Charlotte Storm Water
600 East Fourth Street
Charlotte, N C 28202-2844
OFFC: 704 . 336 . RAIN
FAX: 704 . 336 . 6586

Rezoning Petition Review

Rezoning Petition #: 08-90

Location of Property: Approximately 7.06 acres located on the southeast corner of W. Arrowood Rd. and Sandy Porter Rd.

STORM WATER MANAGEMENT

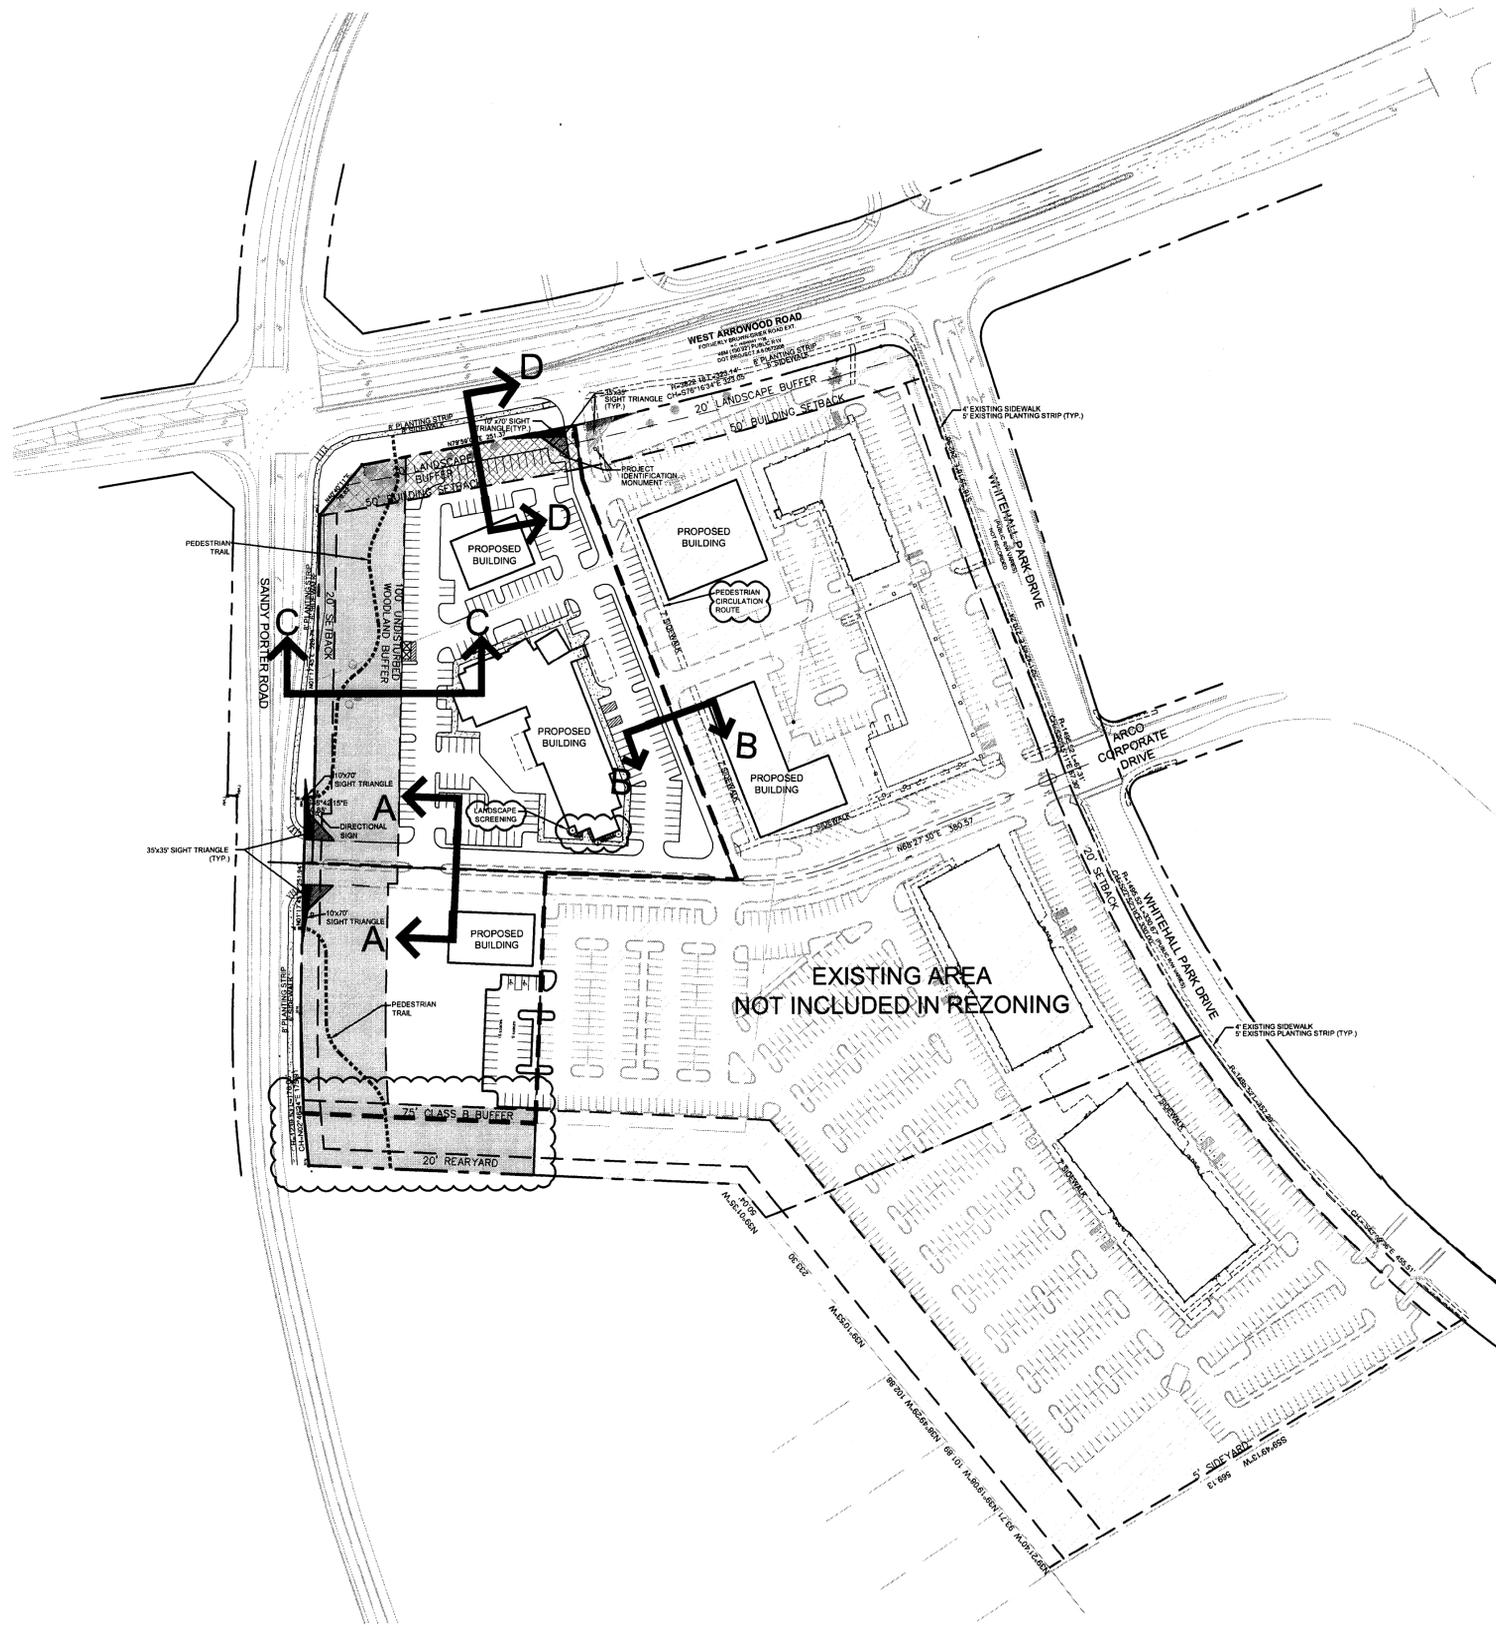
Concerning Storm Water: **Under the Storm Water Management Section remove Note # 2 and include the following notes on the petition.**

The petitioner shall comply with the Charlotte City Council approved and adopted Post Construction Controls Ordinance.

The following agencies must be contacted prior to construction regarding wetland and water quality permits:

Section 401 Permit NCDEHNR – Raleigh Office (919) 733-1786
Section 404 Permit US Army Corps of Engineers (704) 271-4854
